## **Group submission relating to application SSD 5878**

### **Sydney International Convention, Exhibition and Entertainment Centre Precinct – Mixed use Development in the Southern Haymarket Precinct (Concept Proposal) (SSD)**

### **Mixed use Development in the Southern Haymarket Precinct (Concept Proposal) (SSD)**

Figure 5.3. Building heights site diagram

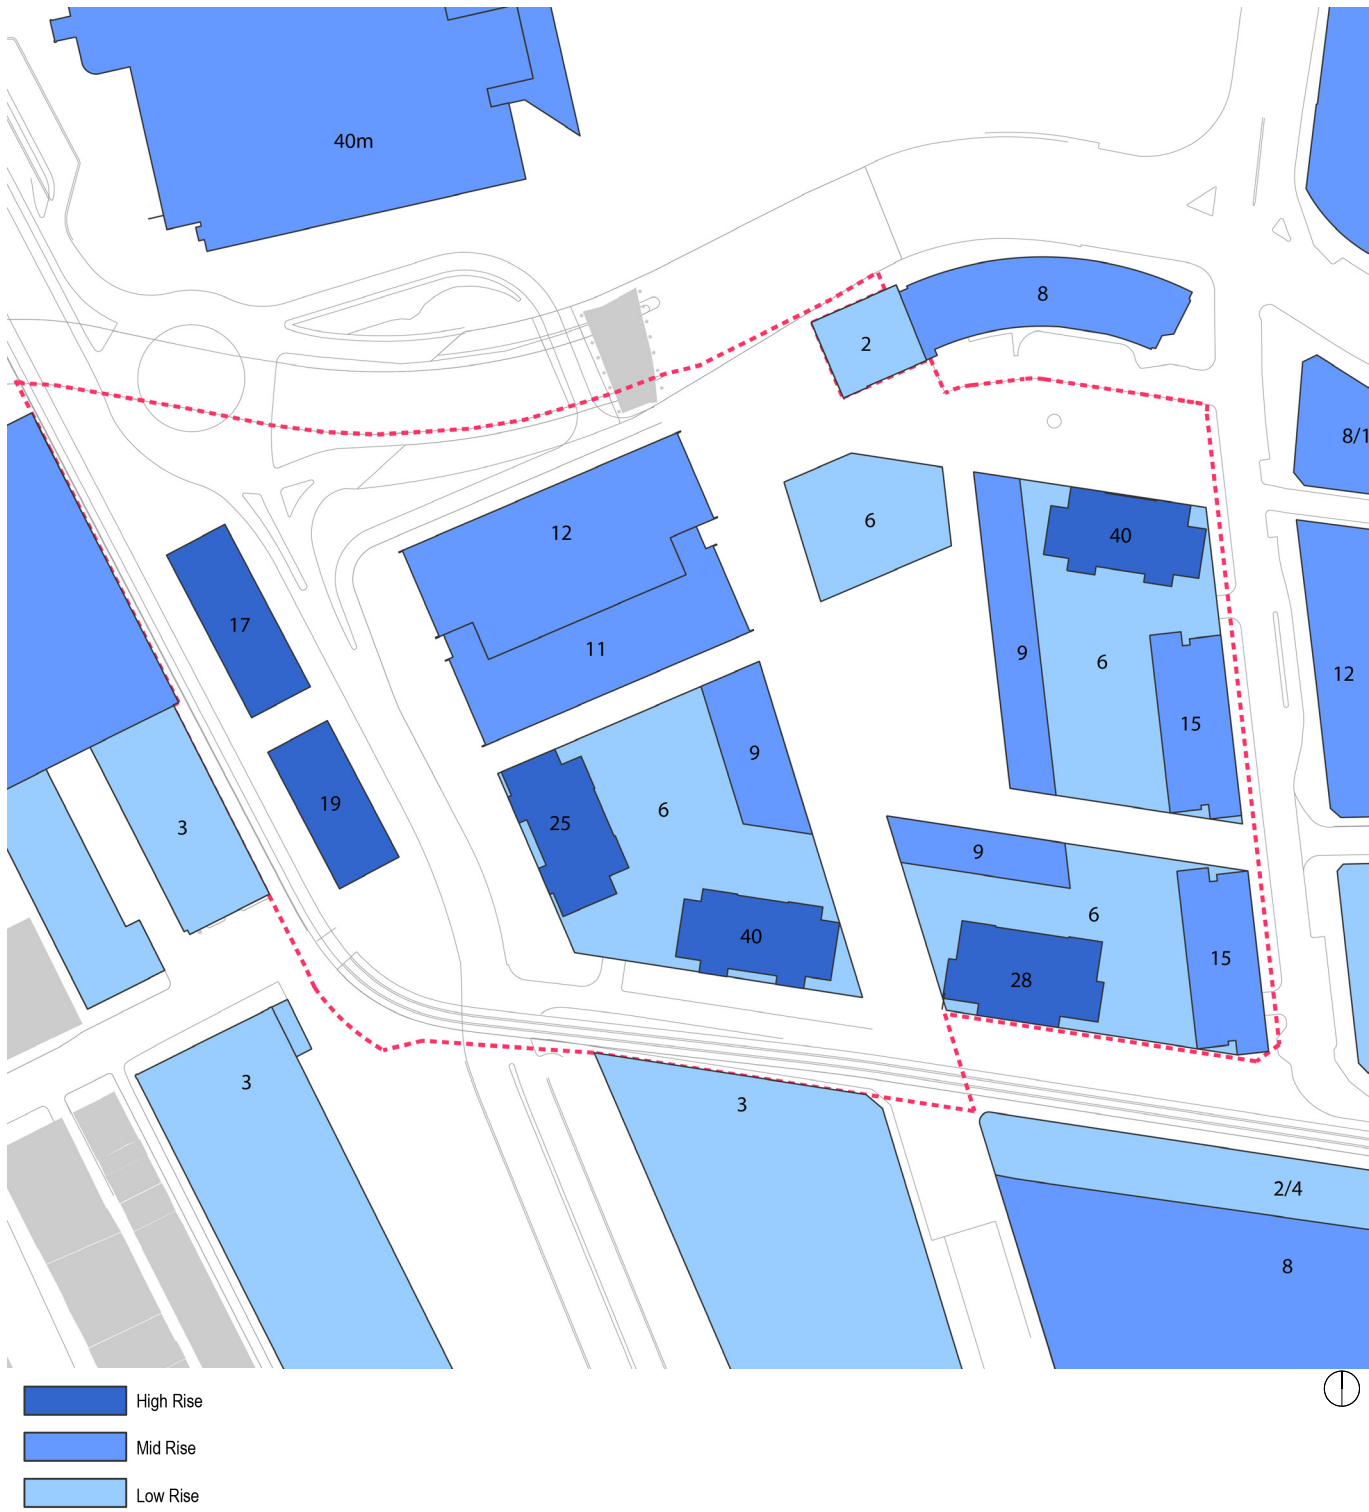
The student accommodation is on public land on a very narrow site between the Powerhouse Museum and Darling Drive. Narrowing Darling Drive will result in greater traffic congestion on this vital access road. Any significant view of the heritage-listed Powerhouse Museum will be obliterated, begging the question about the purpose of heritage-listed buildings.

With the proposed obliteration of the view from the east of the Powerhouse Museum by the student accommodation and the diminution of the setting of the Chinese Gardens it is hard to give credence to the proposal statement "There will be no impact on heritage items located either within the development site or in its vicinity....".
